CD V_2.pdf Markup Summary

GEC V_2.pdf Markup Summary

DEVELOPED CONDITIONS  
DRAINAGE PLAN  
LORSON RANCH EAST FILING NO. 2

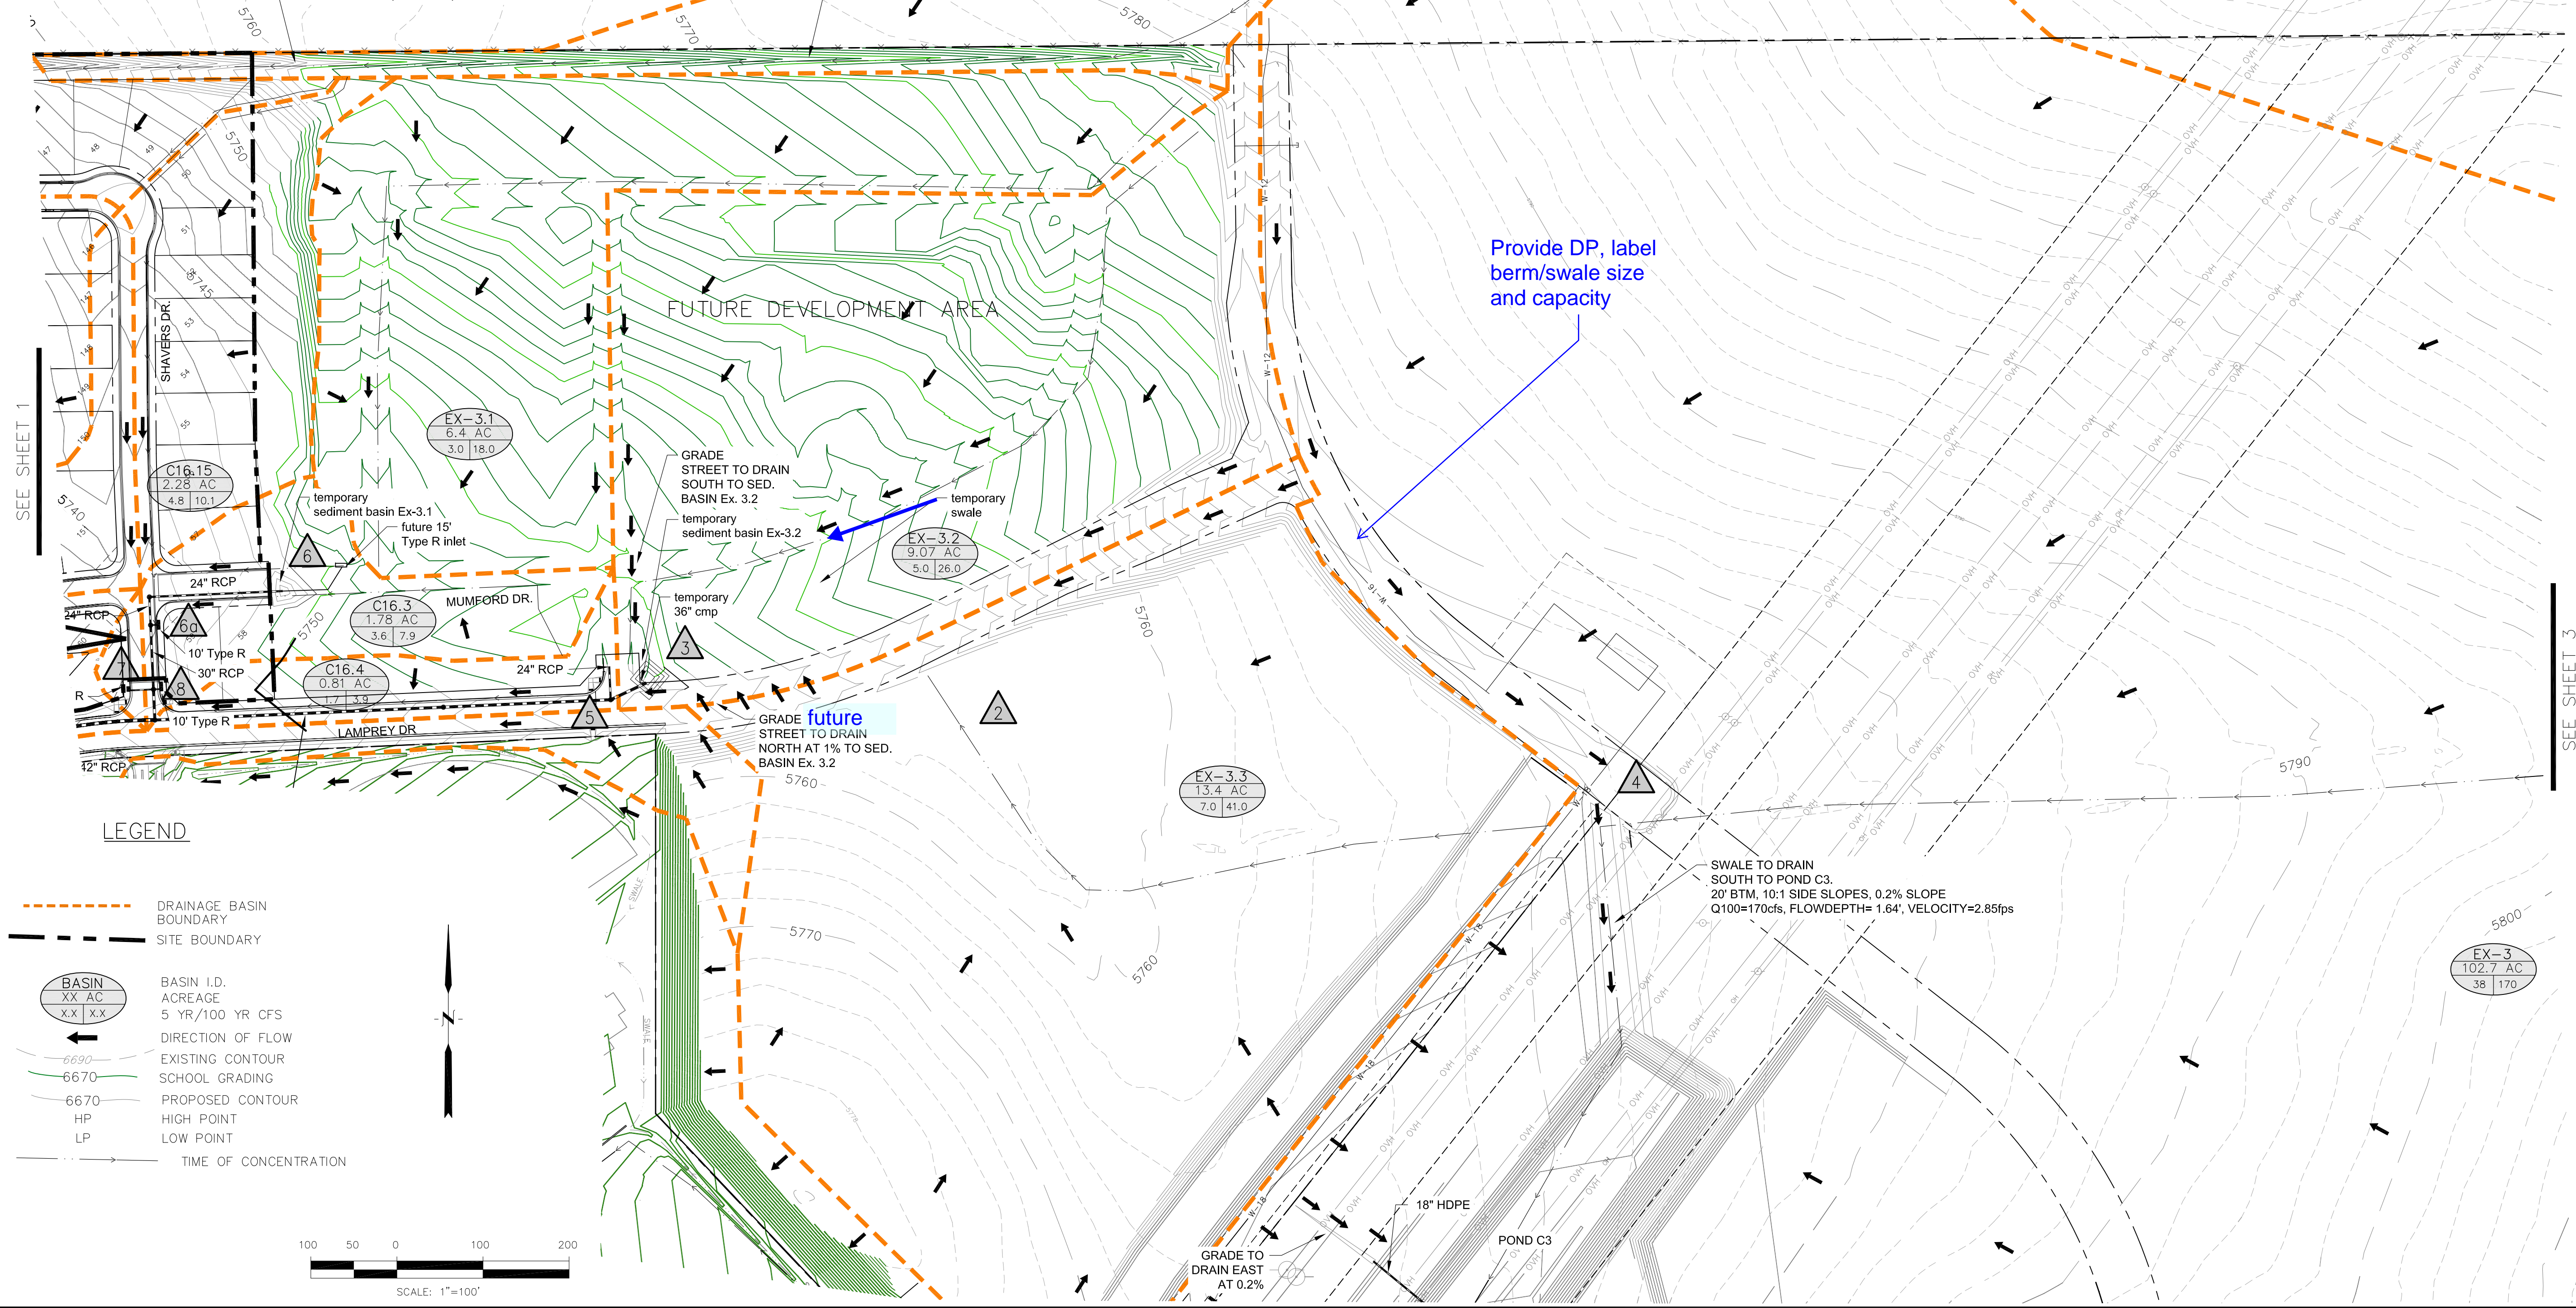
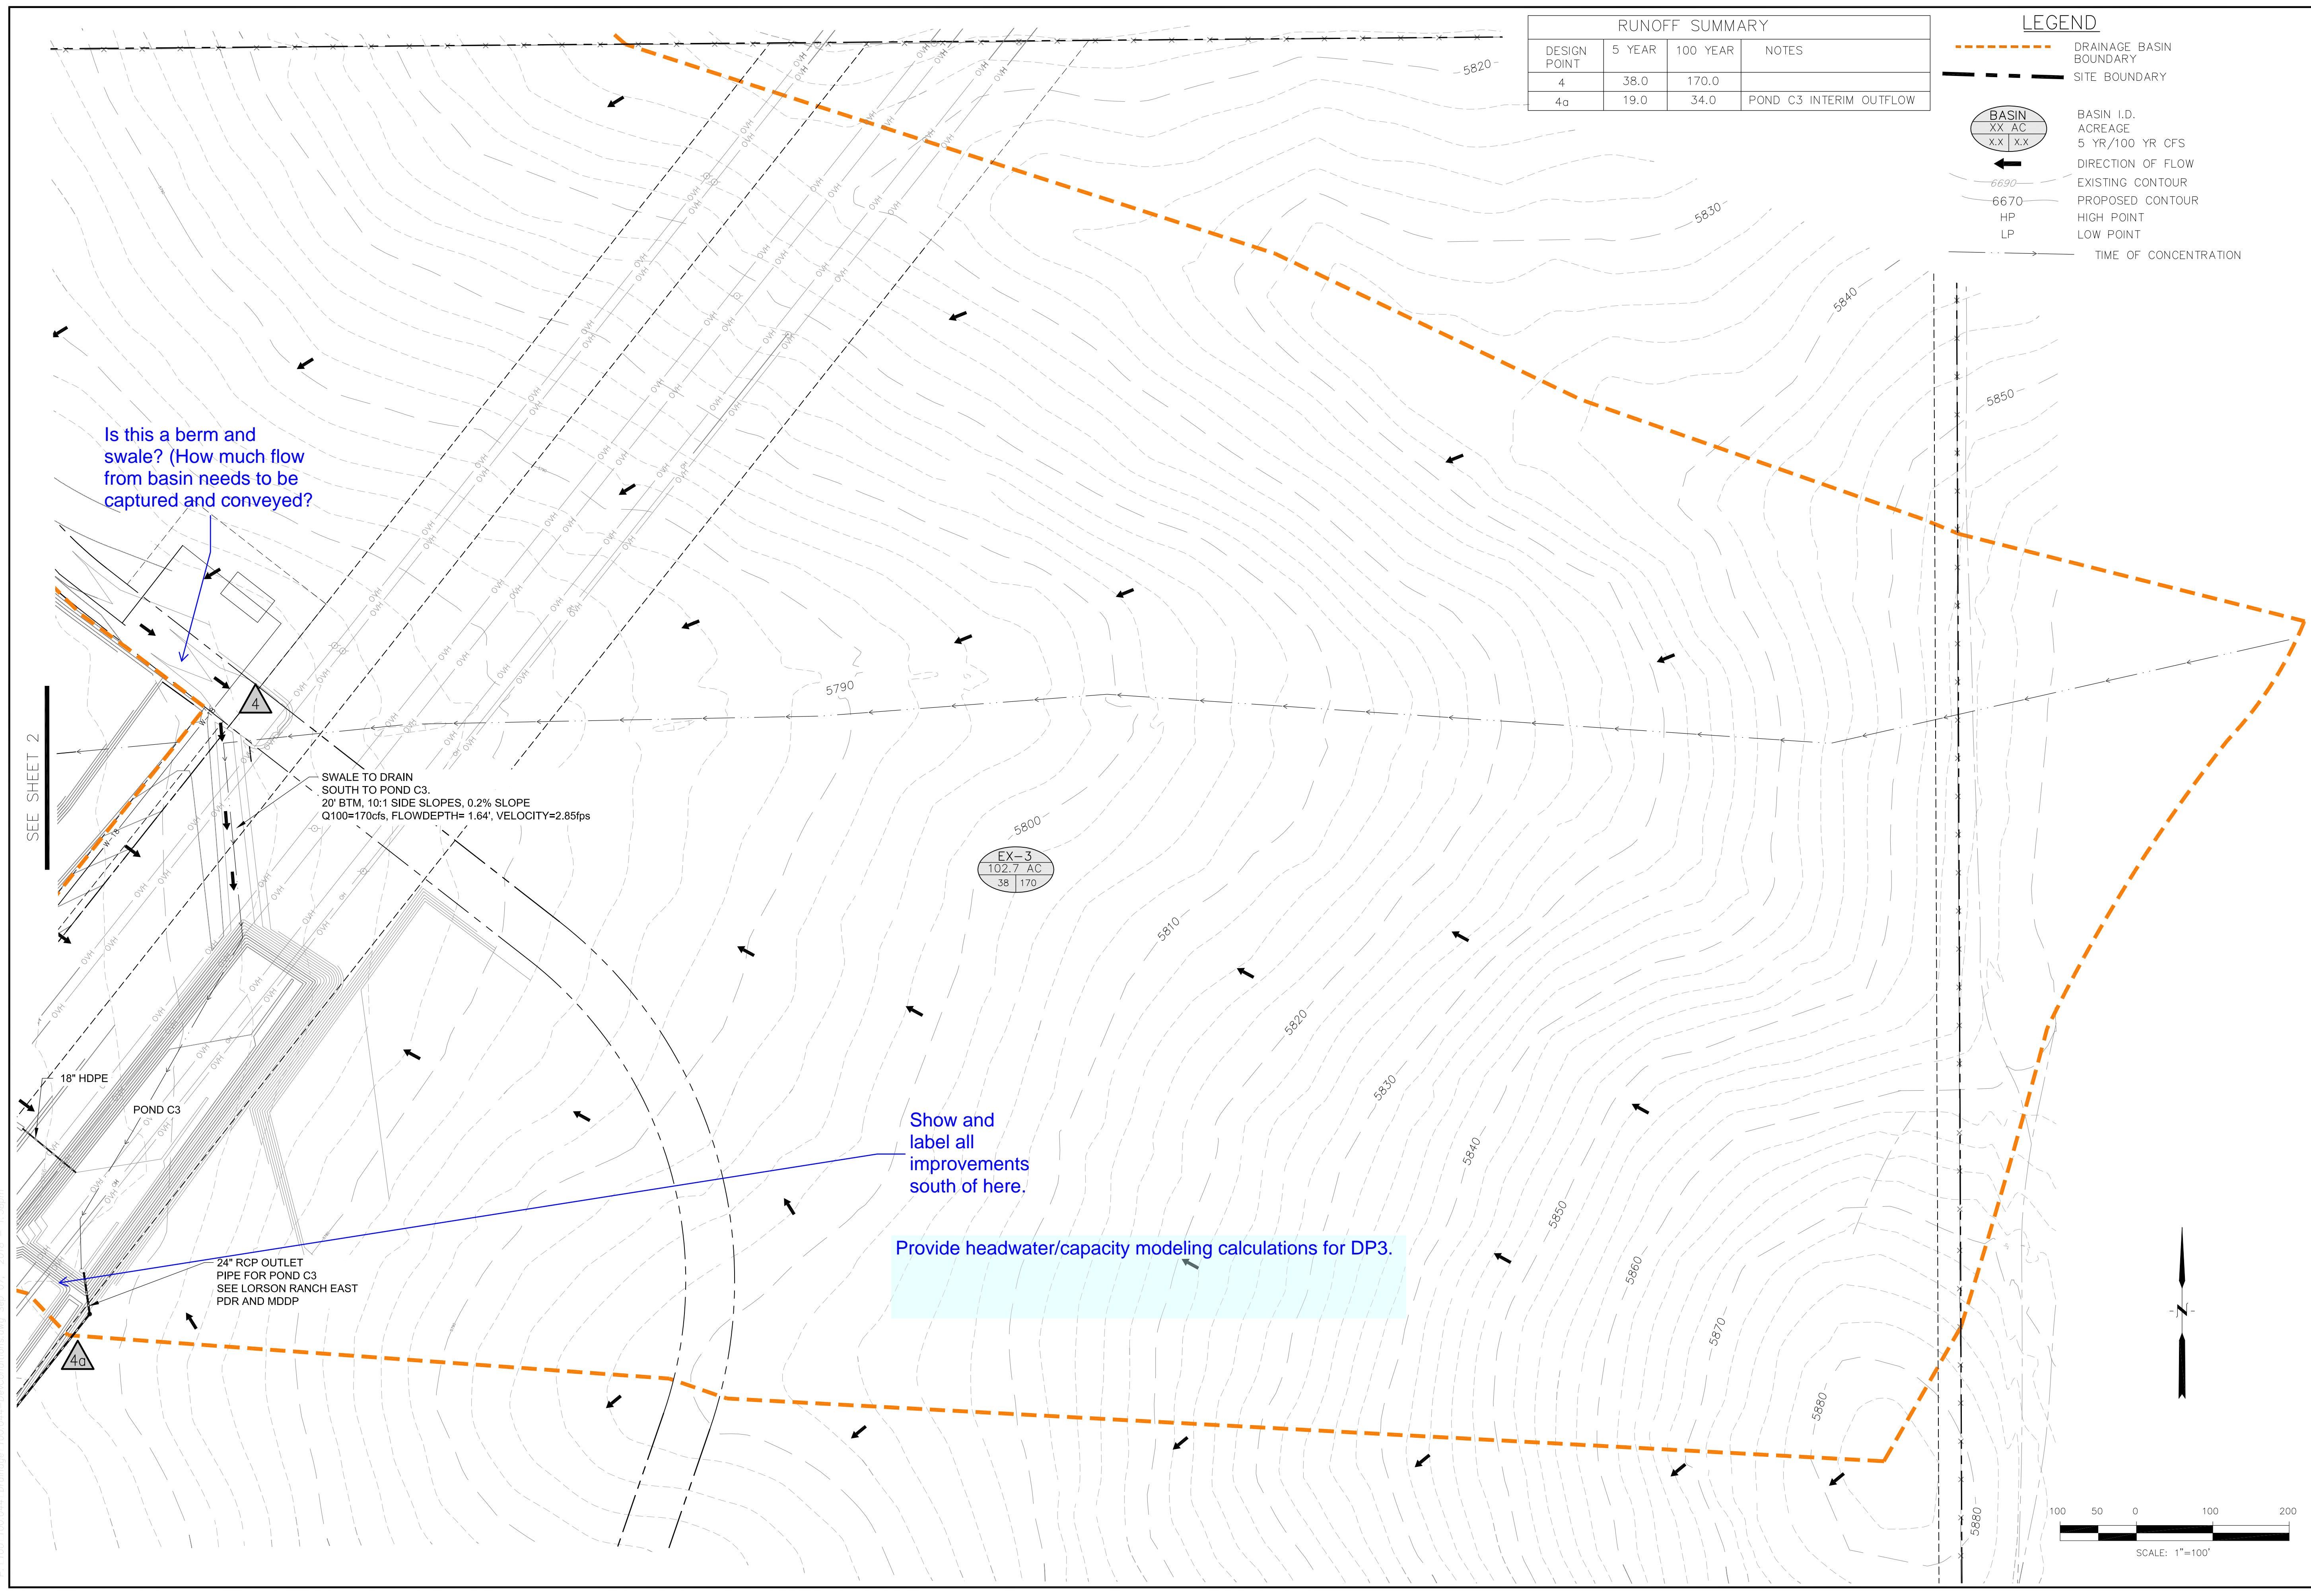
Provide DP, label berm/swale size and capacity

Provide headwater/capacity modeling calculations for DP3.

Show and label all improvements south of here.

Is this a berm and swale? (How much flow from basin needs to be captured and conveyed?)
